**Office of
Environment
& Heritage**

Your reference: SSD 6604
Our reference: DOC16/133038
Contact: Miranda Kerr
Ph 6022 0607

**RE: Griffith Solar Farm Project (SSD 6604) – Griffith LGA
Environmental Impact Statement Exhibition**

ATTACHMENT A Detailed comments for the Griffith Solar Farm Project Environmental Impact Statement (SSD 6604)

Figure 3. Location of recorded artefacts.

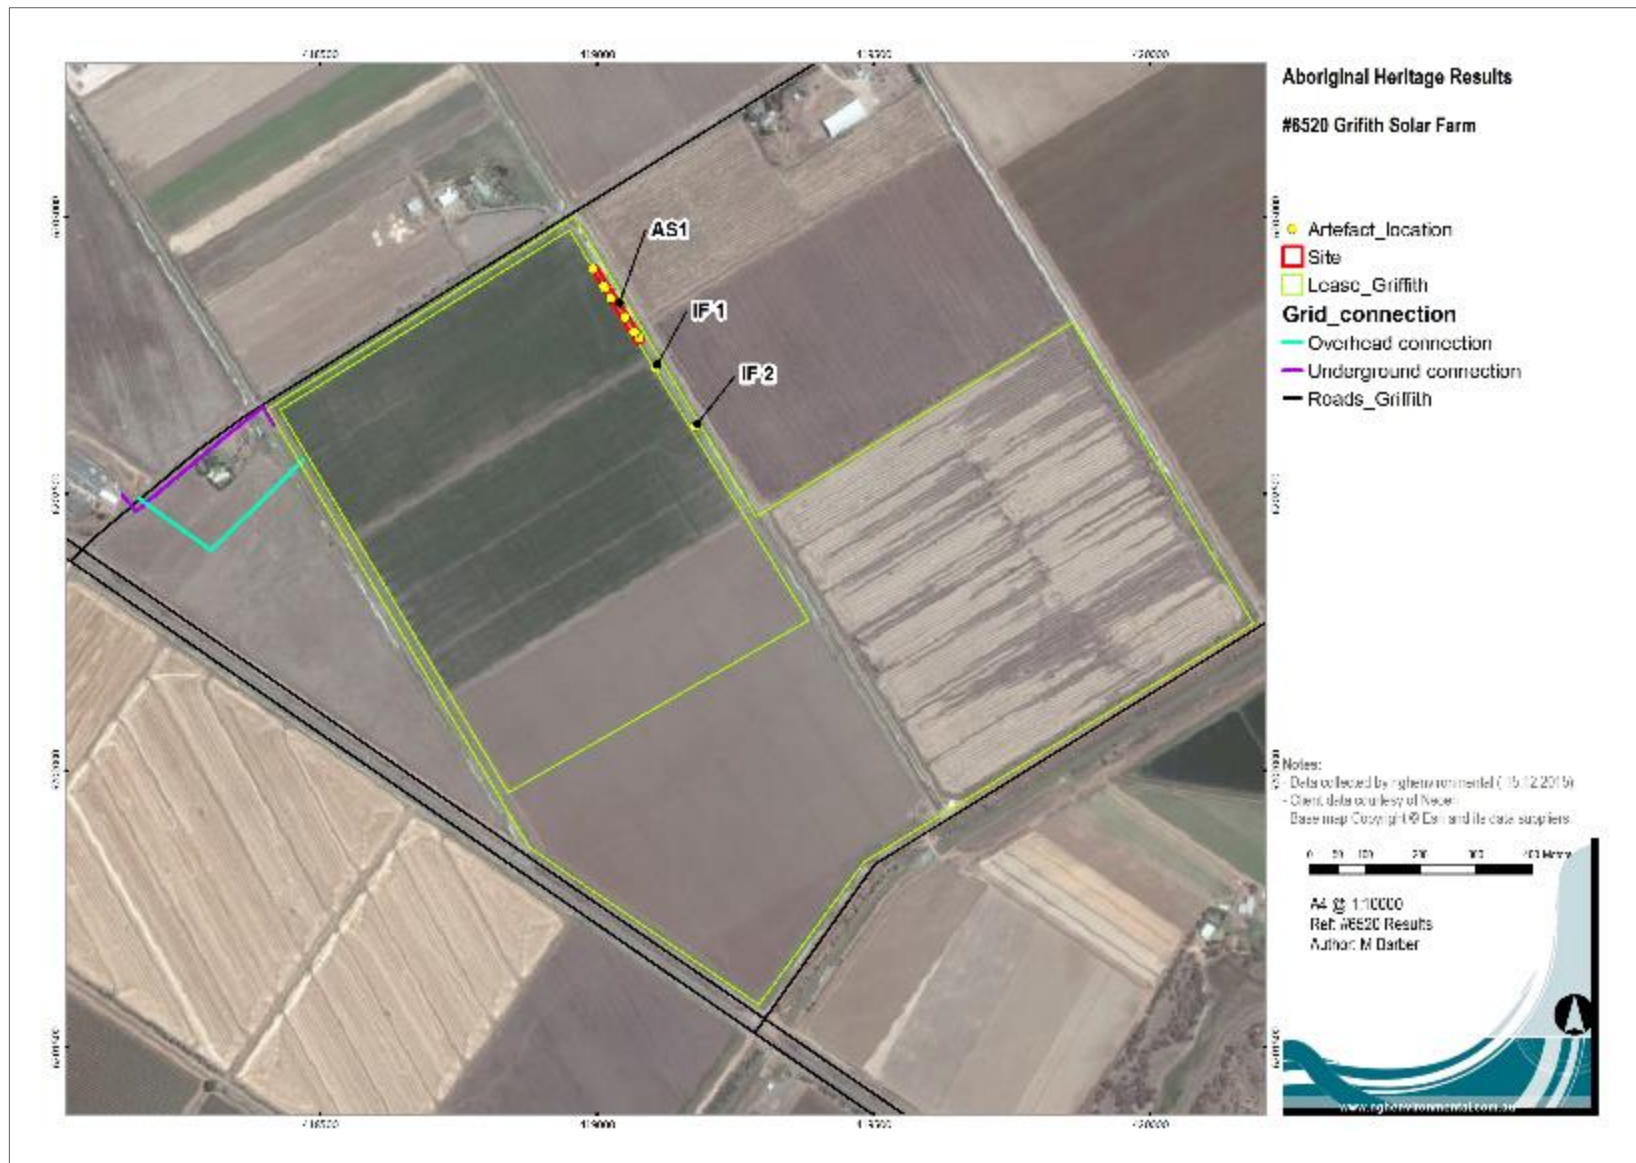
From the ACHA (Section 4.3, page 16) it would appear that the sites found during the current survey have not been submitted to the Aboriginal Heritage Information Management System (AHIMS). Insufficient location information is provided in the report to enable OEH to accurately re-locate the sites if necessary.

The objects are located on the Poletta Road access route. There is no detail about how the sites will be protected during the construction and operation of the proposal, or if they will be relocated.

Ground surface visibility during the survey was very poor and affected the ability of surveyors to see potential objects (section 4.2, page 14). There is a significant likelihood that more ACH is present in the low visibility area where solar panel erection is planned. Mitigation measures have not been defined and site monitoring has not been proposed.

It is not clear within the EIS or supporting information how the proposed activities will impact/harm known sites nor have any alternatives to harm been considered (such as relocating vehicle access points or site layout modification and adjustment of proposed development activities).

- *Aboriginal sites identified during the visual inspection need to be reported to AHIMS in the prescribed format for formal registration of the objects.*

- *If objects are to be temporarily removed and returned to the site, an Aboriginal Site Impact Recording Form needs to be completed following salvage of the archaeological material:*
www.environment.nsw.gov.au/resources/cultureheritage/120558asirf.pdf.

- *A Cultural Heritage Management Plan be prepared that will:*
 - *Confirm the cultural values of the site and objects, based on feedback from the Griffith Local Aboriginal Land Council.*
 - *Outline specific avoidance and mitigation measures for the proposal, including monitoring during construction.*
 - *Consider and detail alternatives to harm prior to any application for an Aboriginal site impact or Care Agreement.*
 - *Include site impact recording forms for any sites modified as part of the activity (this includes collection).*
 - *Detail how objects are to be protected during construction and operation if they are relocated.*
 - *Describe how relocated objects are returned to the original site context during the decommissioning stage, or what other long term management arrangements may be made.*
